From: Jean Fraser
To: Marc Poulin
CC: Lee Allen
Date: 12/21/2015 11:38 AM
Subject: RE: checking in - 171 Warren Ave - parking lot expansion

1. **Parking:** The site plan states that there is 3330 sq ft of offices in the building, and therefore the zoning requirement (per the ordinances) for this project would be 9 parking spaces (eg 1/400 sq ft)- which is what we originally approved. The Site Plan ordinance has this requirement (see underlined sections as most applicable):

Drawing Name:
SITE PLAN

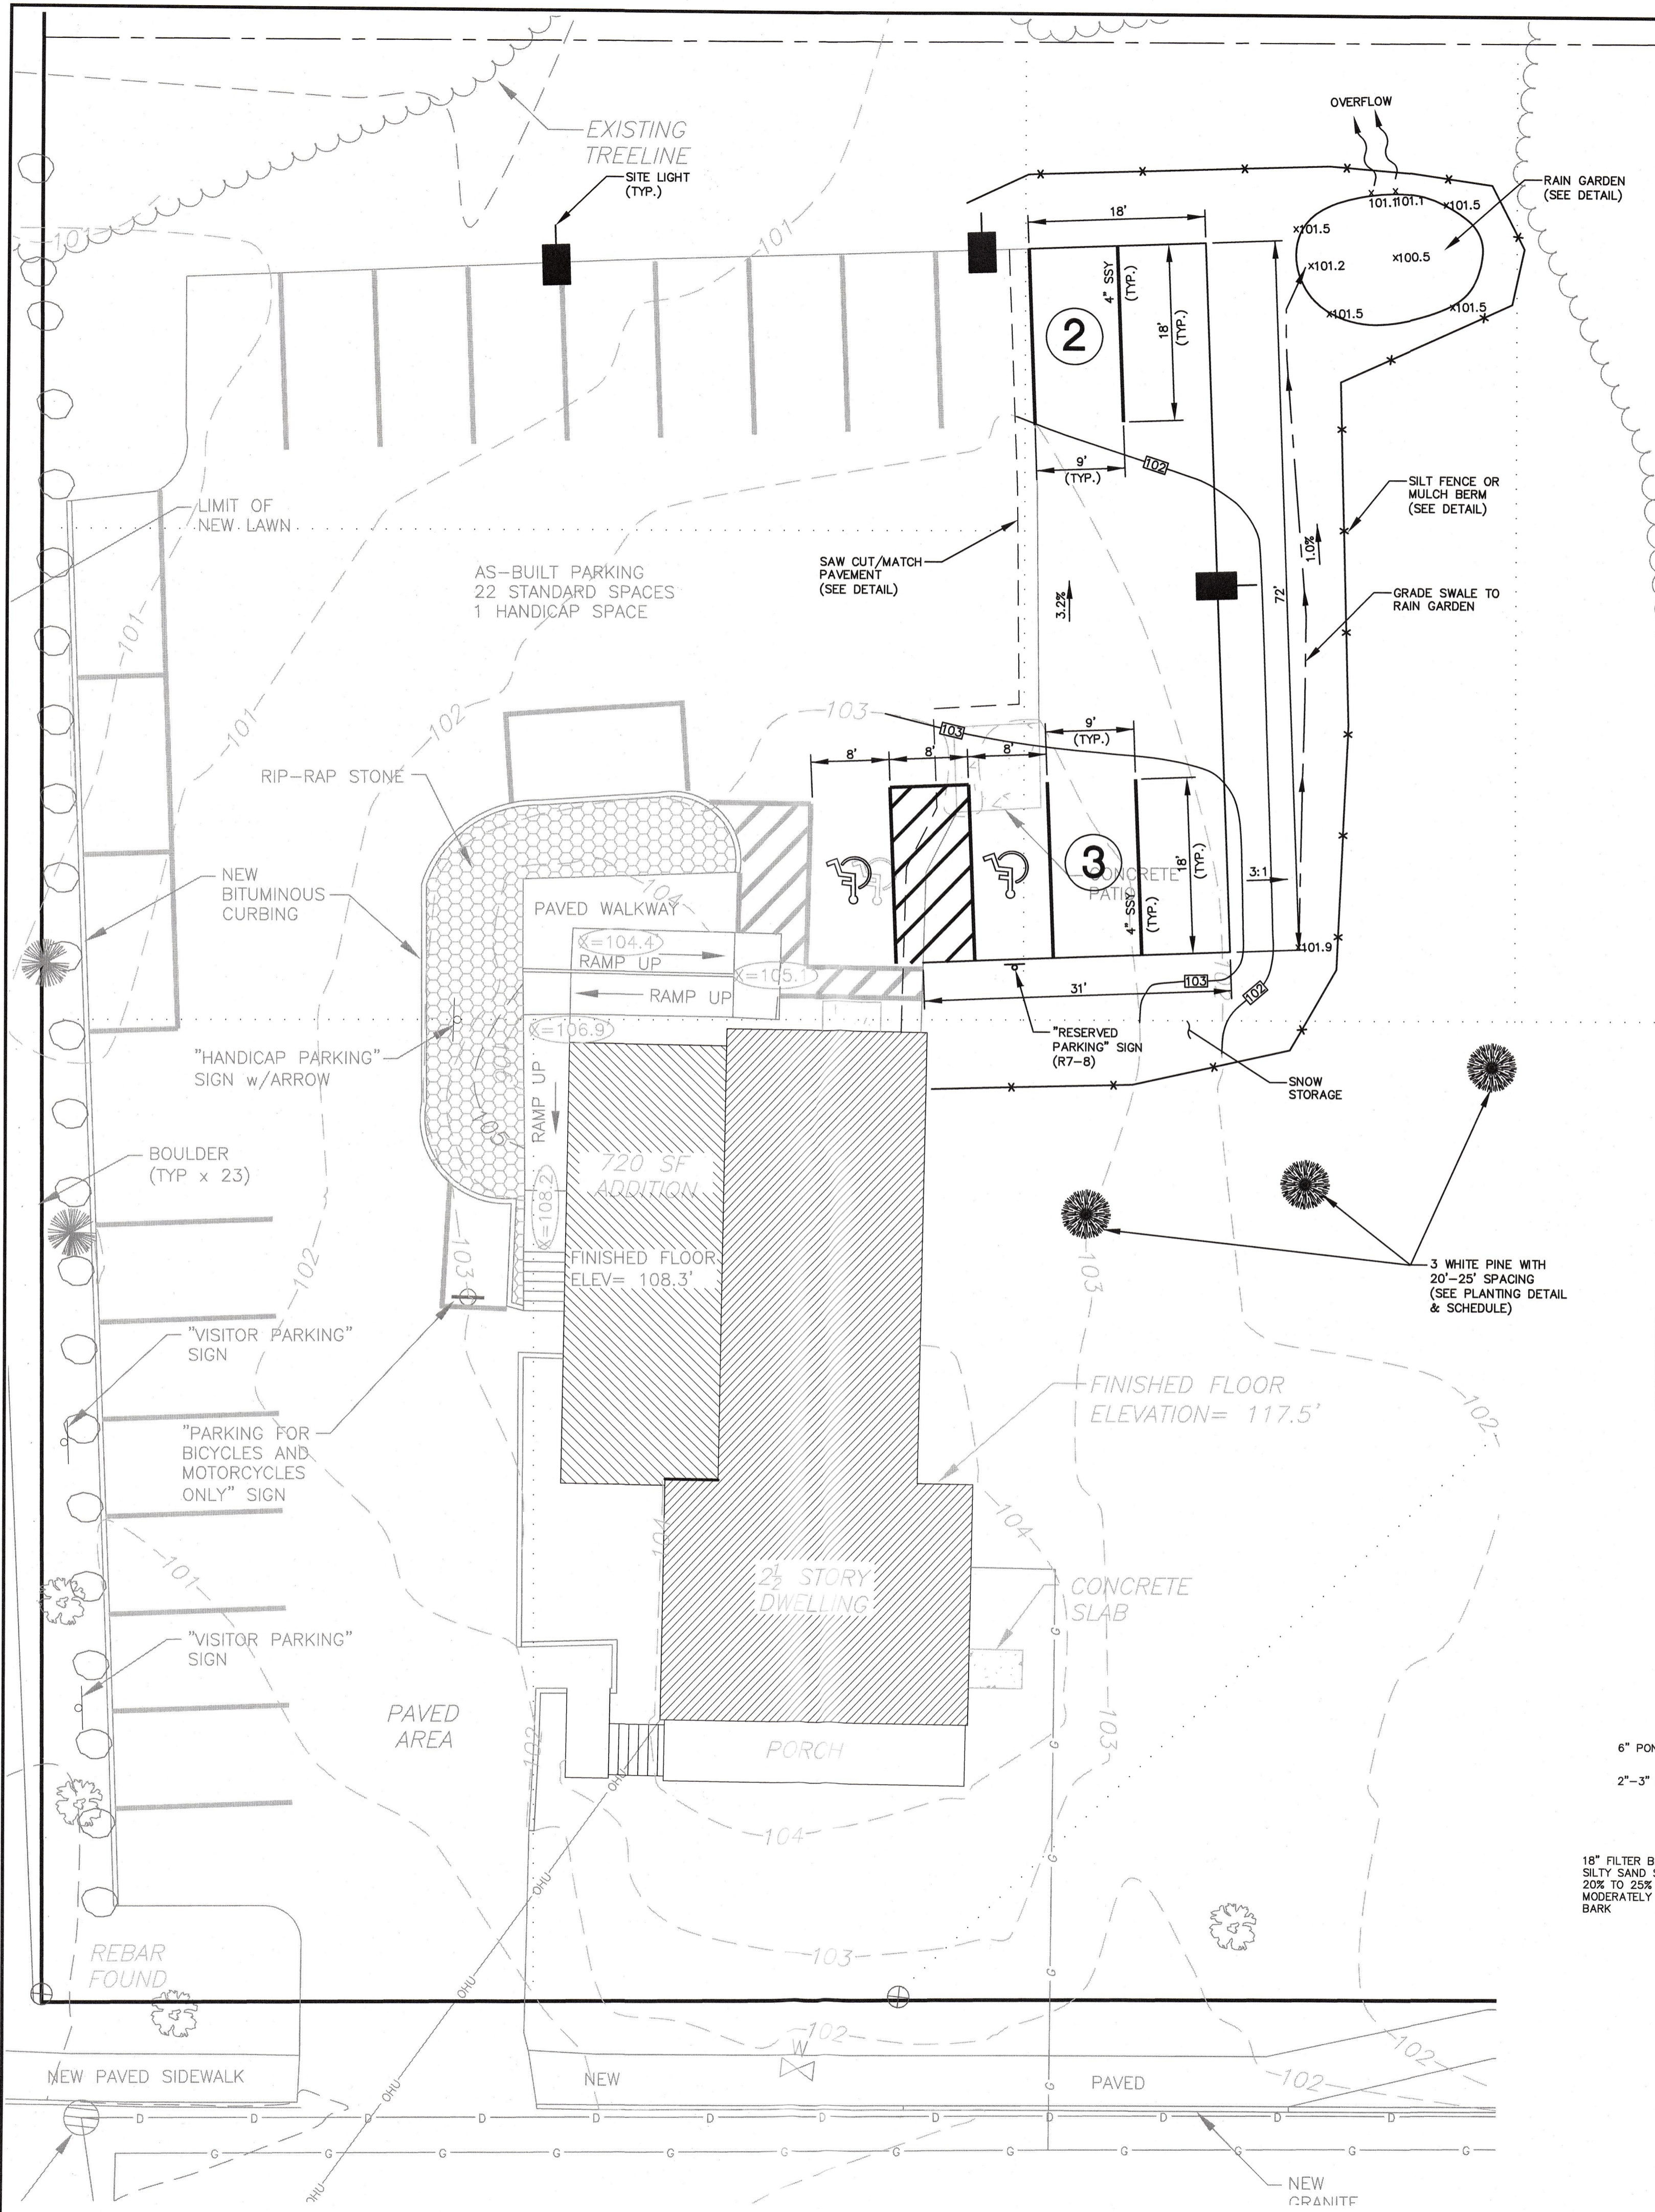
So there are two questions: what is the correct office floorspace for your building (our assessors entries suggest its a lot more than 3330 sq ft); and if its less than 9200sq ft then there needs to be a narrative explaining why this much parking is needed.

2. **Landscape:** In a recent telephone conversation with you I advised that landscape screening of the new parking area should be included (screened from Warren). I don't see any landscaping screening on the site plan. The relevant ordinance is (see underlined section as most applicable- I have quoted the entire section for context):

3. **Bicycle parking**: The requirement for bicycle parking is 2 spaces for every 10 parking spaces, or 4 for this project. These need to serve both the employees and the visiting public. Could you confirm how many bike parking spaces you have now- and if this is less than 4 than some would need to be added.
